RE: Large Lot Application LL-09-00001

RE: Easton Ridge Large Lot  
Subdivision (LL-09-00001)

Re: Easton Ridge Large Lot Subdivision LL-09-00001

EASTON RIDGE LARGE LOT SUBDIVISION
A PORTION OF SECTION 1, TOWNSHIP 20 NORTH, RANGE 13 EAST, W.M. KITITAS COUNTY, WASHINGTON

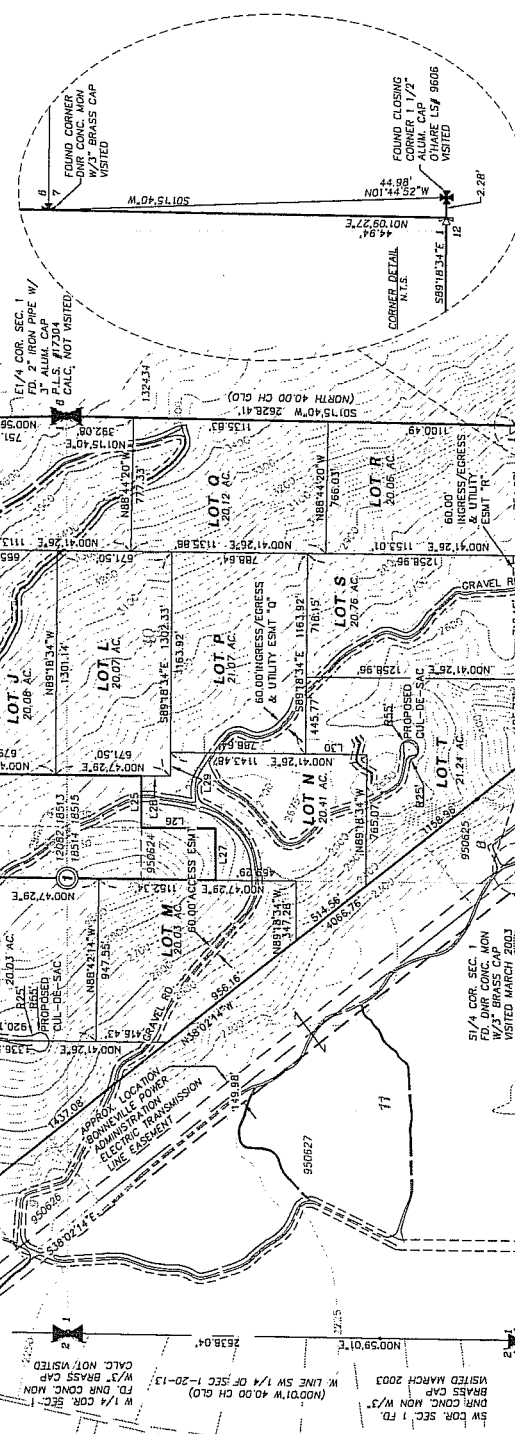
One example is to add **18 individual septic systems on steep slope** (item # 7 Narrative project description. Please review the attached photos of runoff at the base of this steep slope property.

1. Are there under lying motives in this proposal to allow higher density in other areas?
2. The steepness and condition of the current road structure is NOT accessible for fire trucks & aid cars for emergency response.

Upon review of the Easton Ridge Large Lot Subdivision, LL-09-00001 land use action, I have the following comments/requirements;

- An approved private fire hydrant system shall be installed. The hydrant system shall be subject to plan review through the Fire Marshal's Office and shall be subject to an annual Operational Permit.

- Water storage and hydrant spacing shall comply with the International Fire Code.
- The minimum fire flow requirements for the residential structures shall be no less than 1,000 gpm.

- The minimum road width shall not be less than 26' in width.
- A minimum of two fire apparatus access roads are required. The two access roads shall be not less than  $\frac{1}{2}$  the length of the maximum diagonal dimension of the property, measured in a straight line between accesses.

- No fire apparatus access lane shall have a slope greater than 12%.
- "No Parking-Fire Lane" signs must be posted per Fire Marshal requirements.
- All cul-de-sacs must have a minimum turning radius of no less than 50'. The signs mentioned above shall be posted on all cul-de-sacs.
